STATE OF NORTH CAROLINA
DEPARTMENT OF TRANSPORTATION

Addendum No. 1

RE: Contract # C204352

Alamance County (I-5711)

PROJECT REFERENCE NO. I-5711	SHEET NO. 5
ROADWAY DESIGN ENGINEER 3/4/2020	HYDRAULICS ENGINEER 3/4/2020
SEAL 25523 NORTH CAROLINA PROFESSIONAL ENGINEER EXPIRES 12/31/2024	SEAL 20147 NORTH CAROLINA PROFESSIONAL ENGINEER EXPIRES 12/31/2024

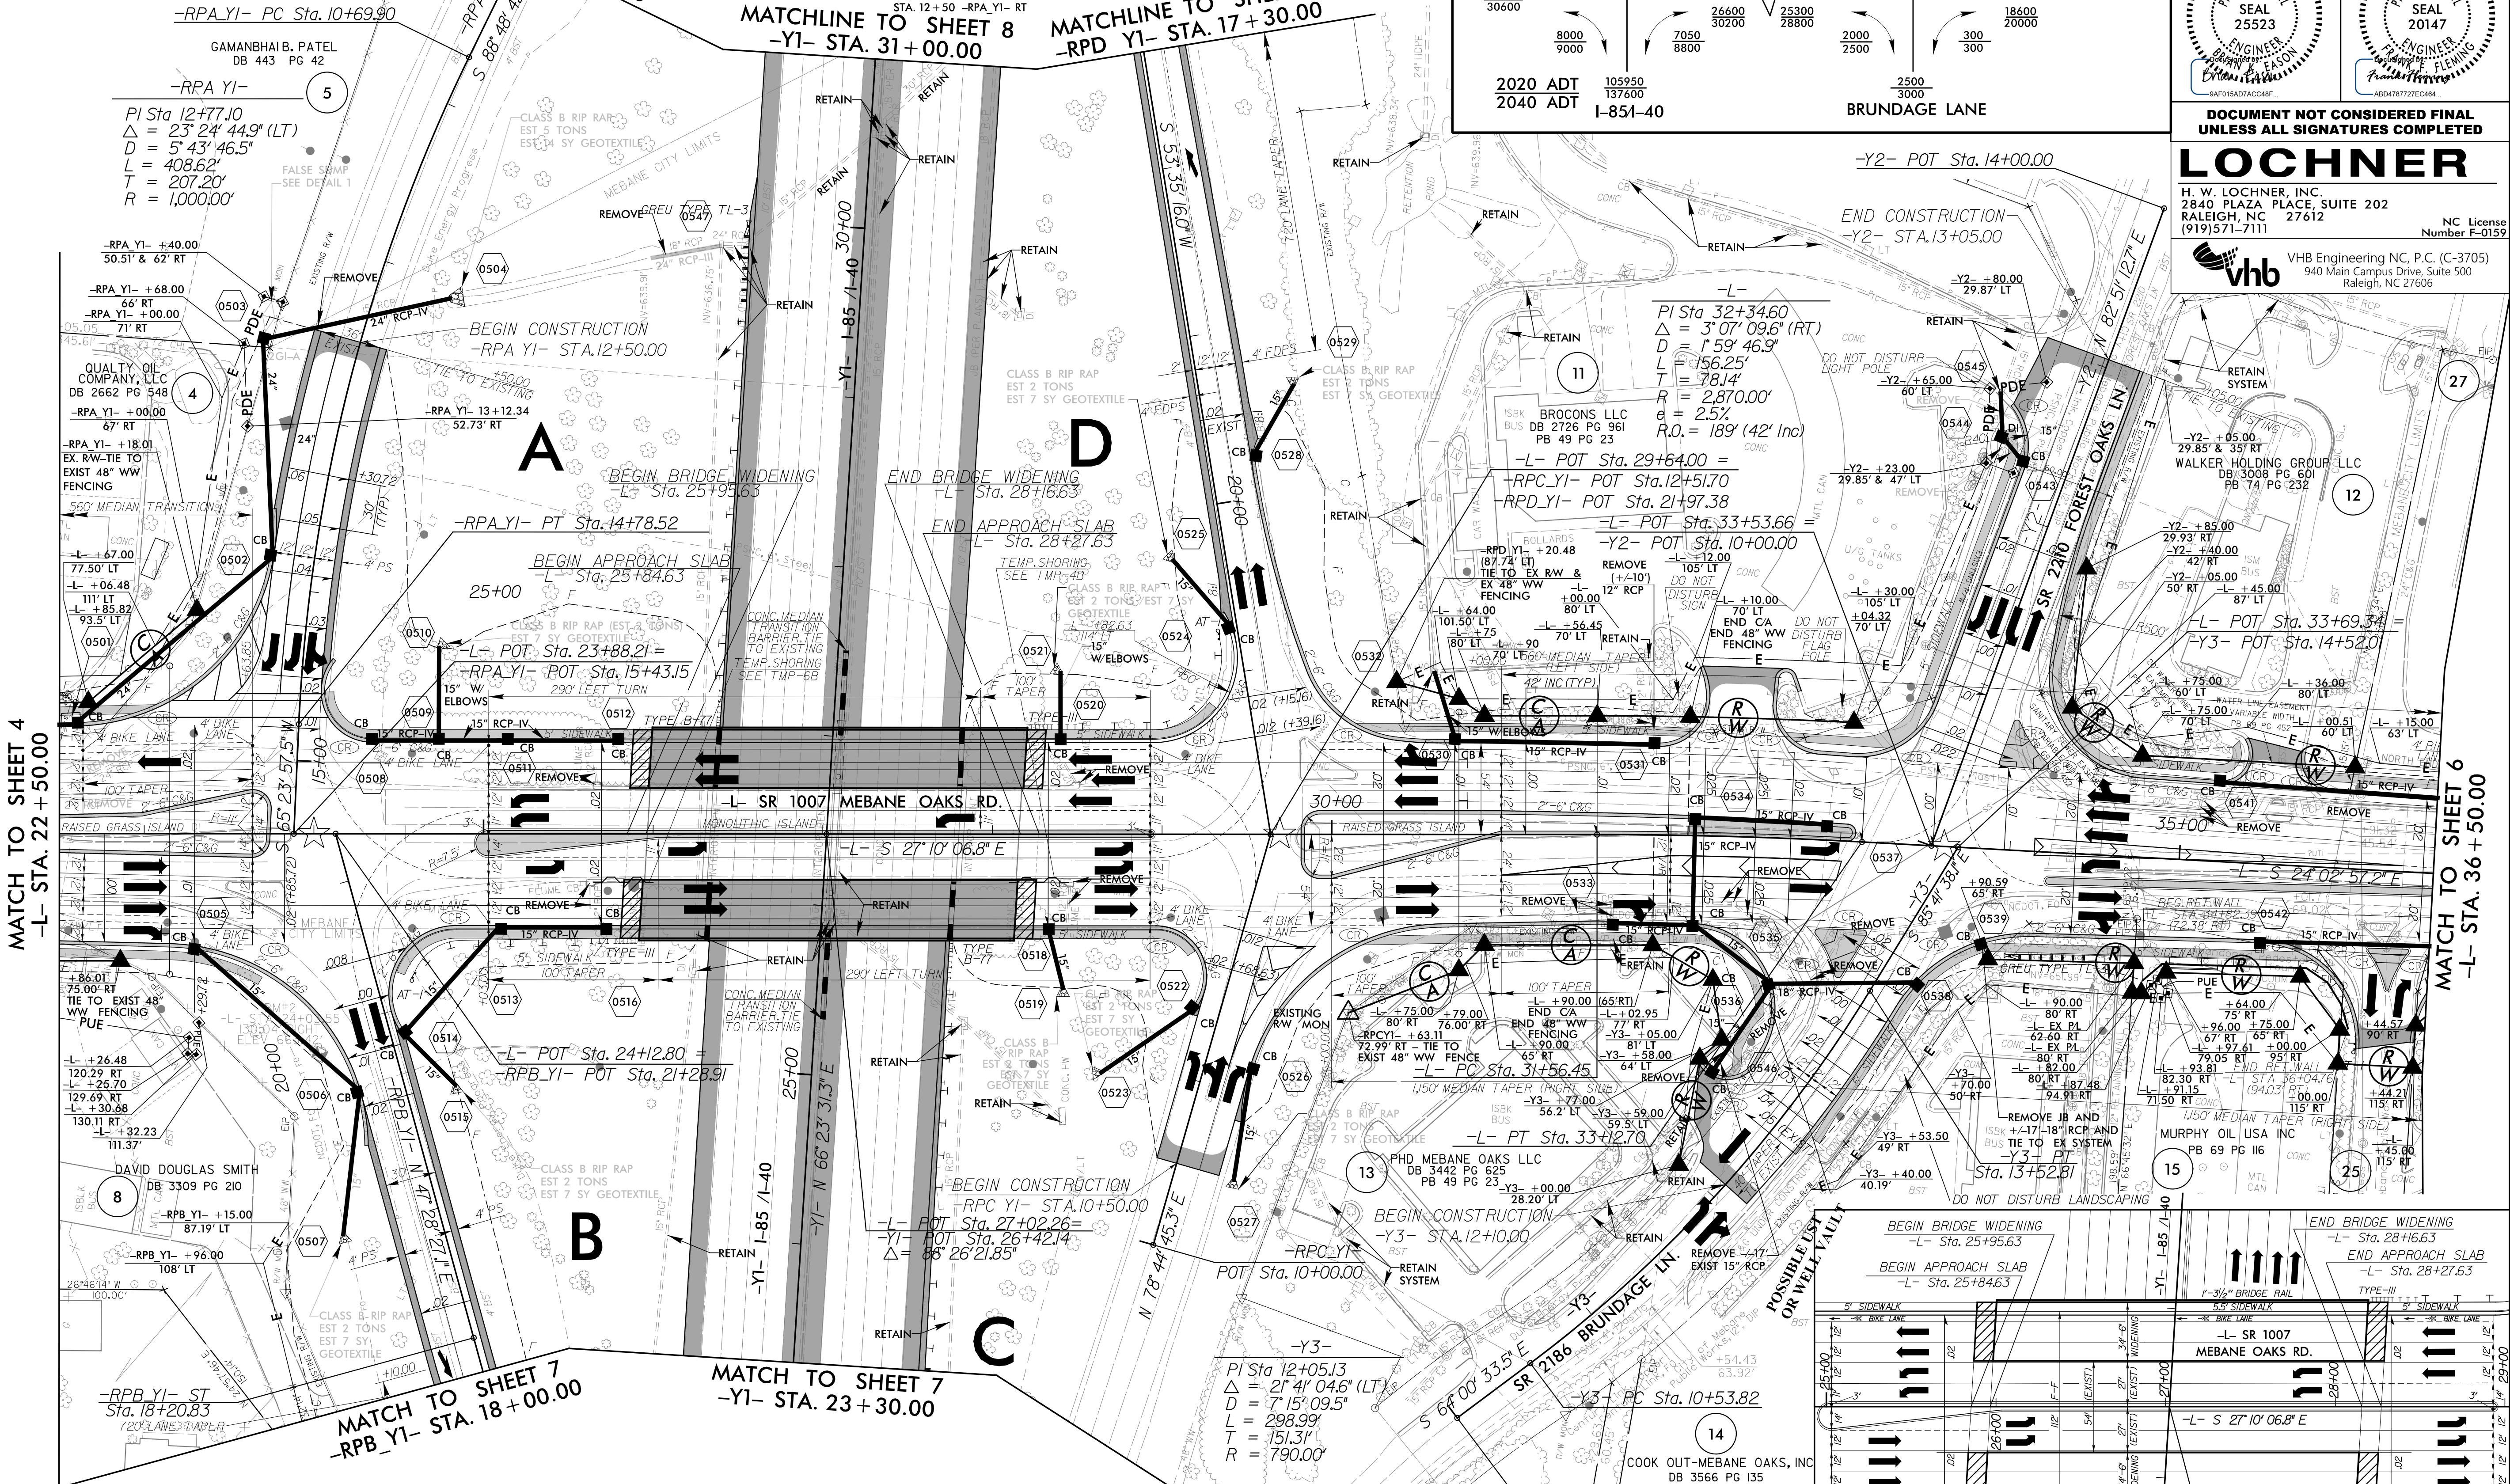
Sheet No.	Revision
5	2 notes added. (DO NOT DISTURB SIGN & DO NOT DISTURB FLAG POLE)
TMP-1 thru TMP-8A	The entire Traffic Management Plan set has been revised.
